CITY OF ALBUQUERQUE
PLANNING DEPARTMENT
DEVELOPMENT REVIEW BOARD

Project# 1007140
13DRB-70672 EXT OF MAJOR PRELIMINARY PLAT

Project# 1007140
12DRB-70177 EXT OF MAJOR PRELIMINARY PLAT

MARK GOODWIN AND ASSOCIATES, P.A. agent(s) for JTH, LLC request(s) the above action(s) for all or a portion of Lot(s) 2A, **JUAN TABO HILLS UNIT 3B** zoned RD-SU1, located on JUAN TABO BLVD BETWEEN MONACHOS RD AND TIJERAS ARROYO containing approximately 9.54 acre(s). (M-22)

AMENDED PRELIMINARY PLAT FOR  
**JUAN TABO HILLS, UNIT 3B**  
 WITHIN  
 SECTIONS 27, AND 34  
 TOWNSHIP 10 NORTH, RANGE 4 EAST, NMPM  
 CITY OF ALBUQUERQUE  
 BERNALILLO COUNTY, NEW MEXICO  
 MARCH, 2012

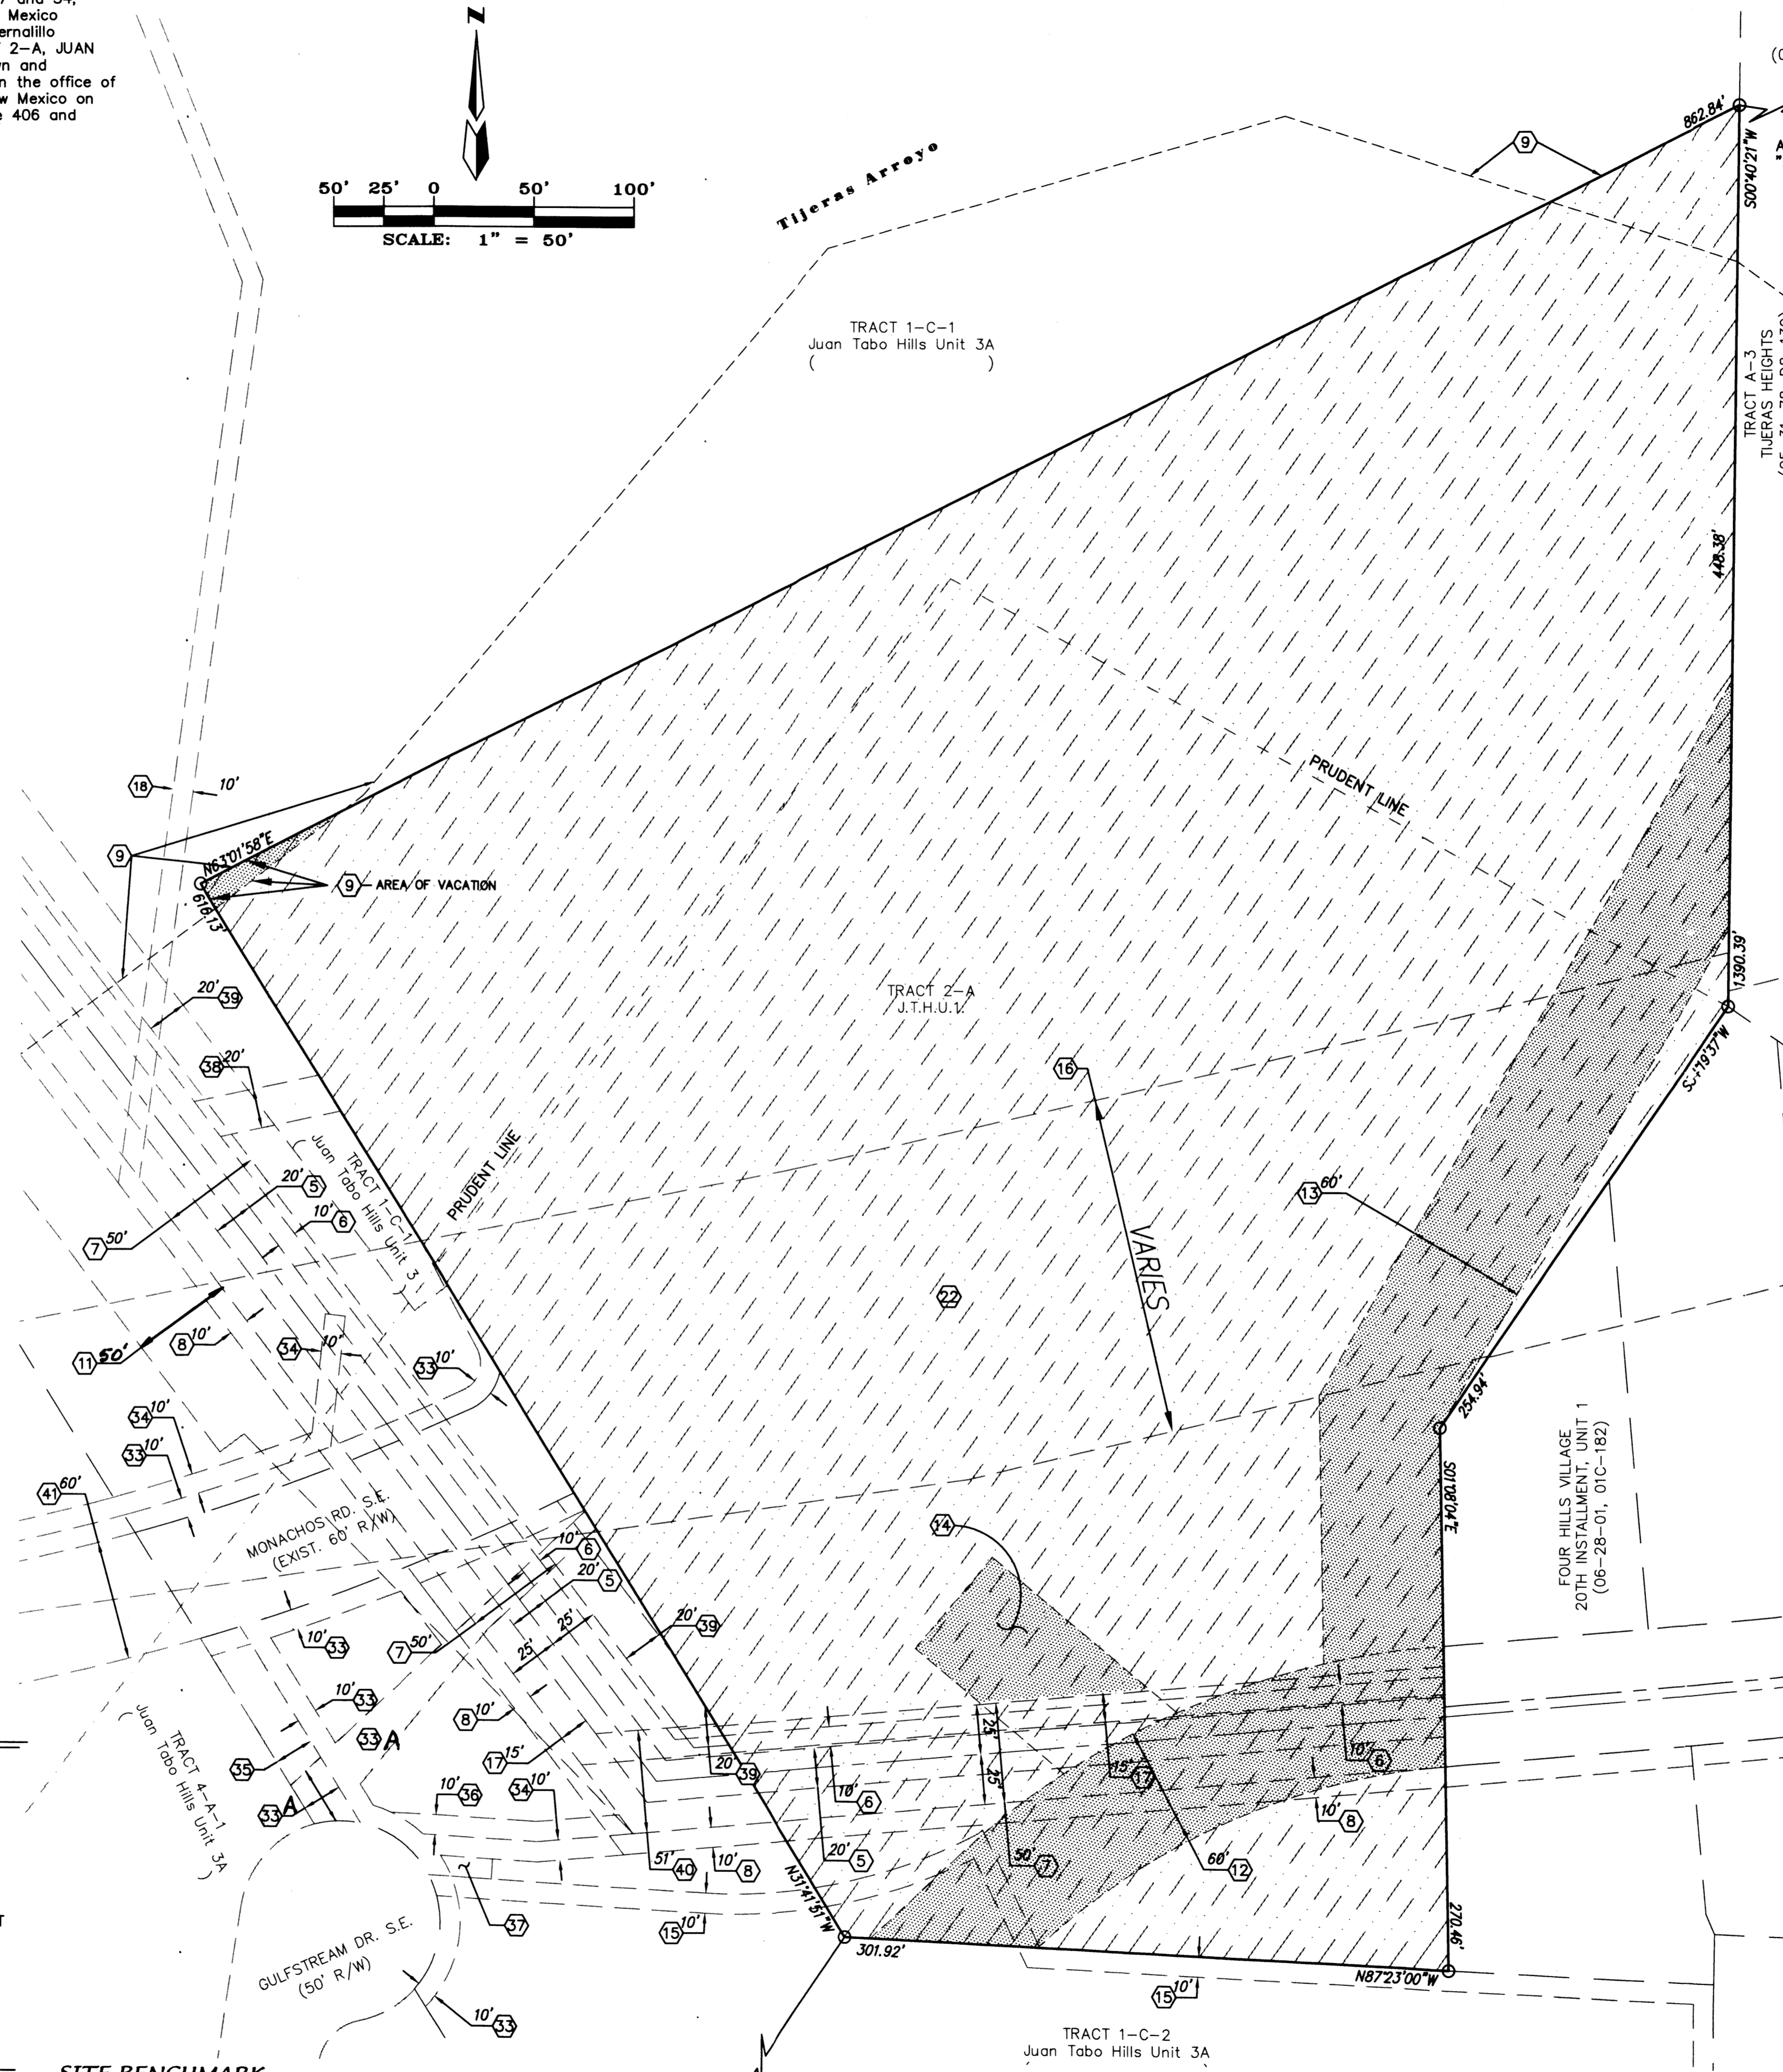
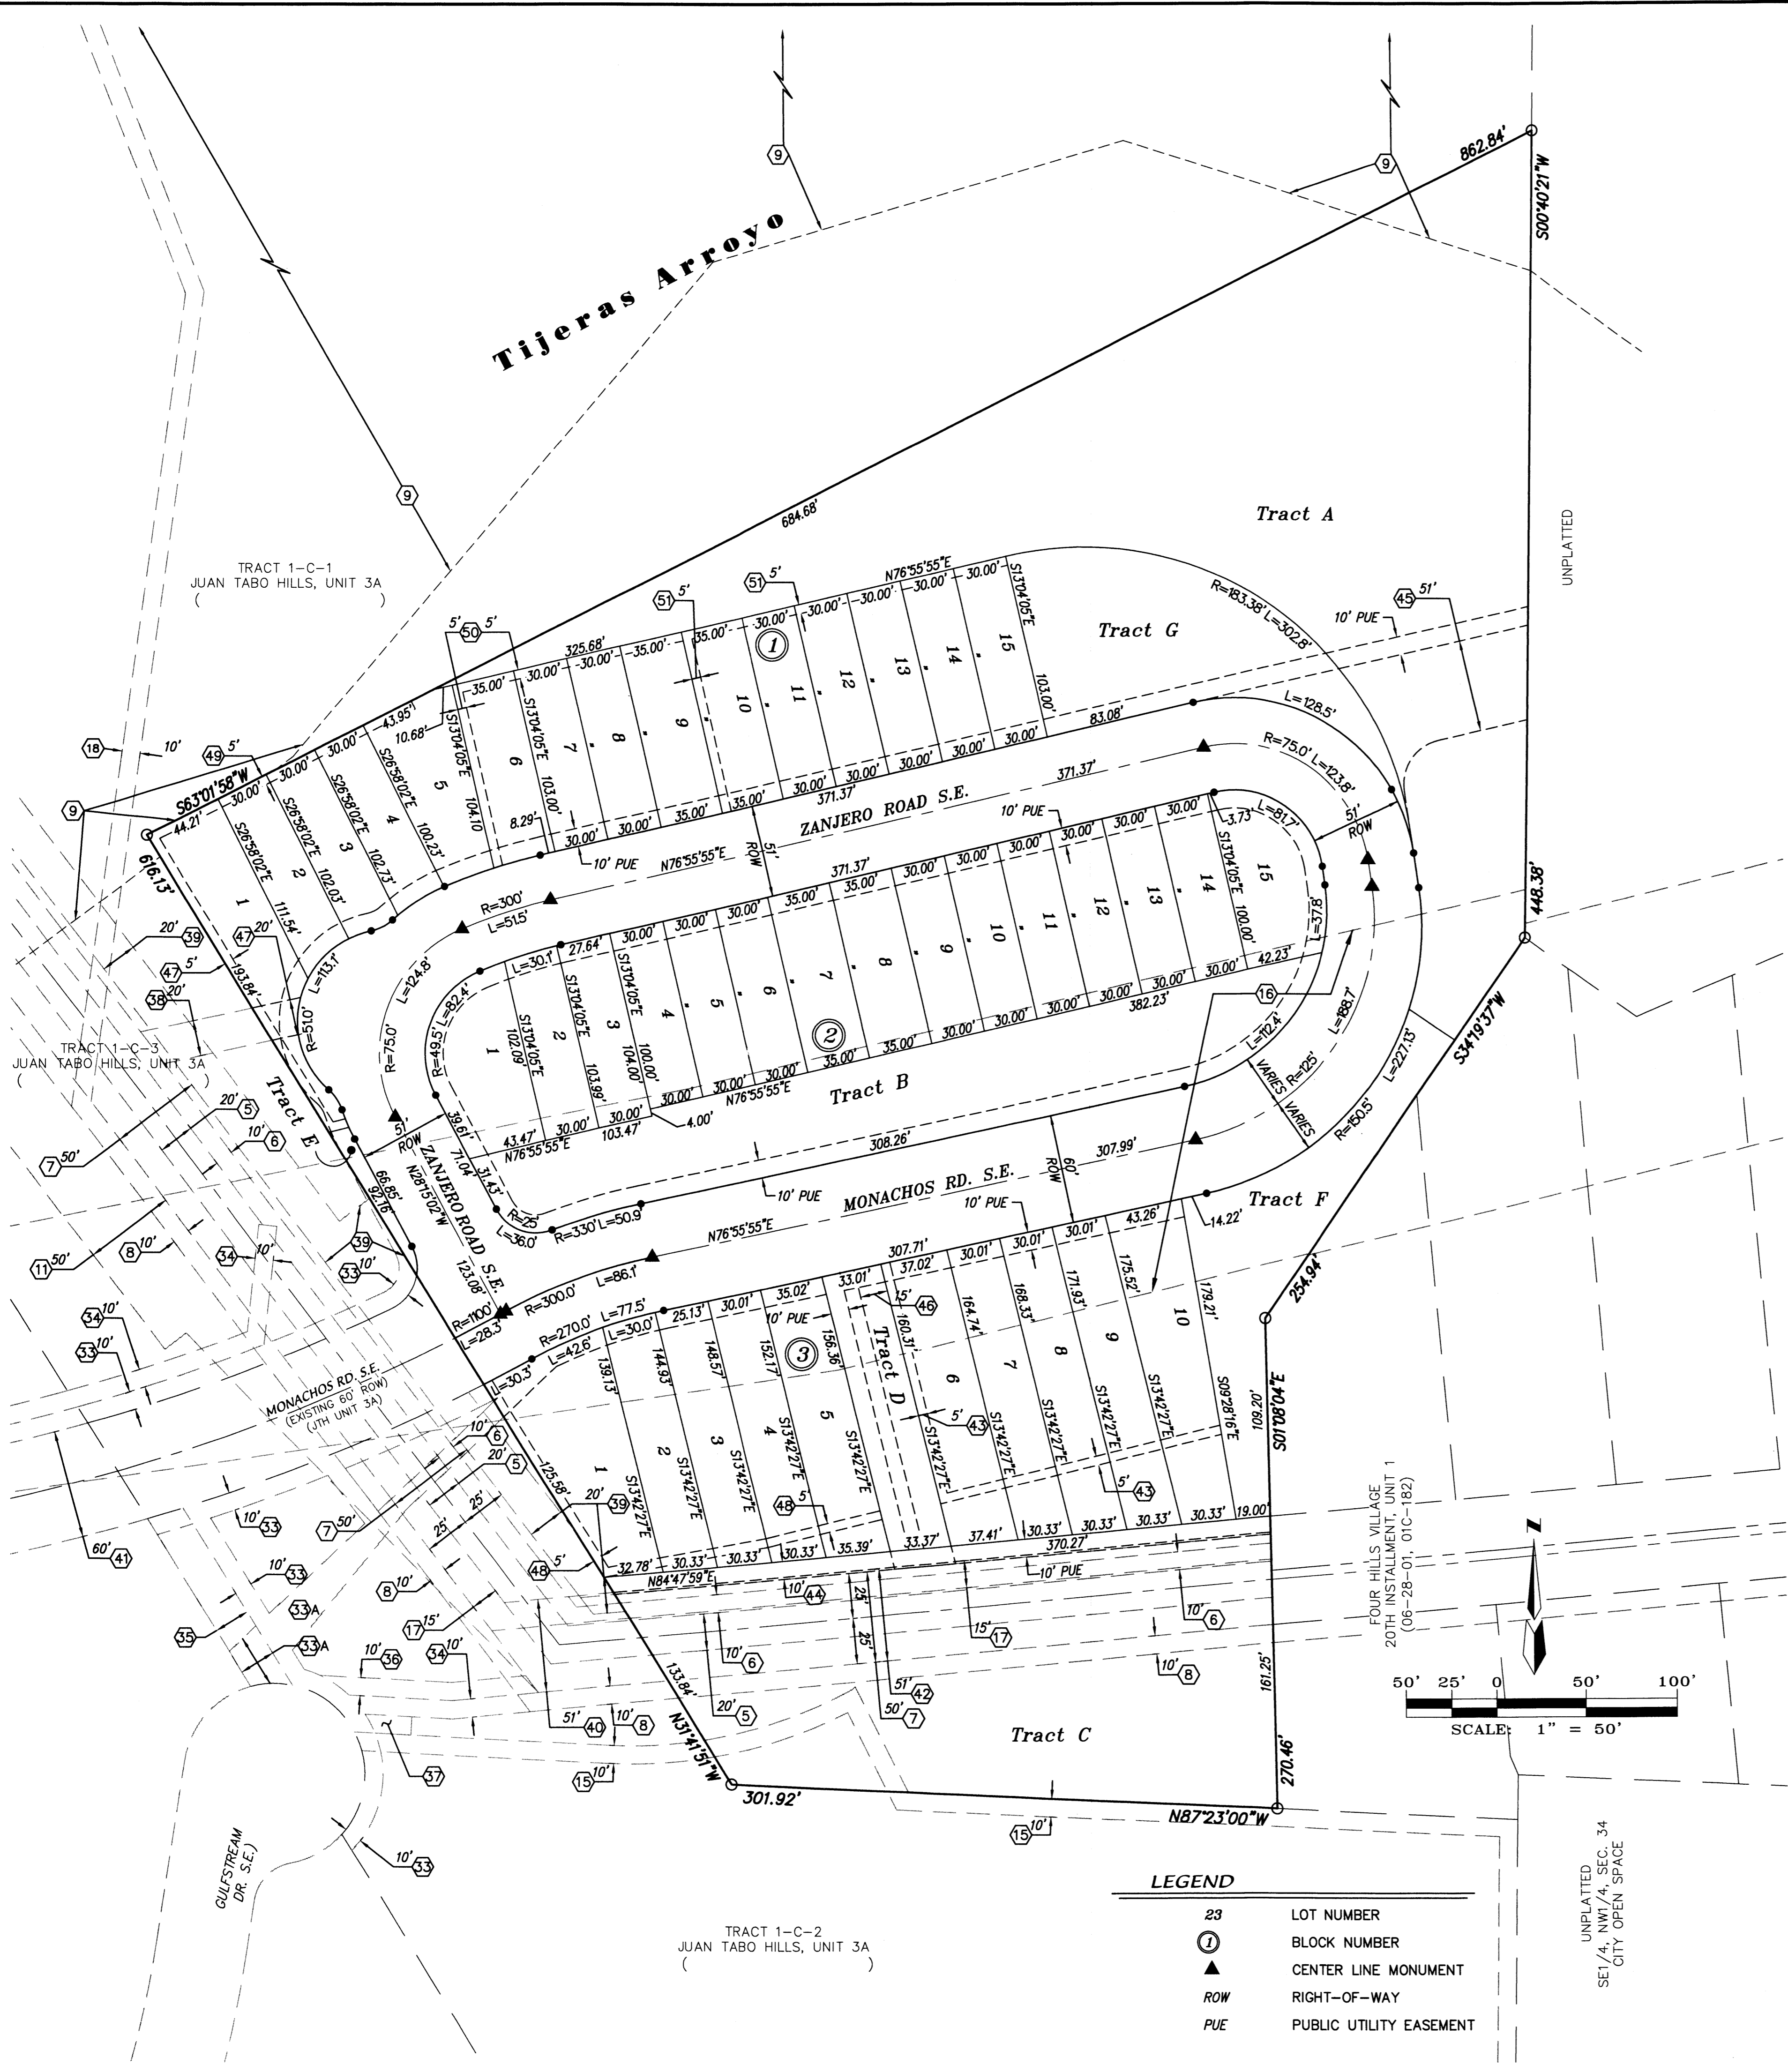
2. Certain changes in the approved Preliminary Plats have been agreed to by the parties during the review of the submitted "Amended Preliminary Plats" and those changes should be noted. For example, including but not limited to, the proposed trail alignment from the Tijeras Arroyo to provide connection to the Four Hills Village as required by EPC, the ownership of the various "open space" tracts A-E shown on the approved Preliminary Plat, and any and all agreements that the parties are able to resolve with respect to the Tract 1-C Open Space outstanding issues referred to on the documents listed above.
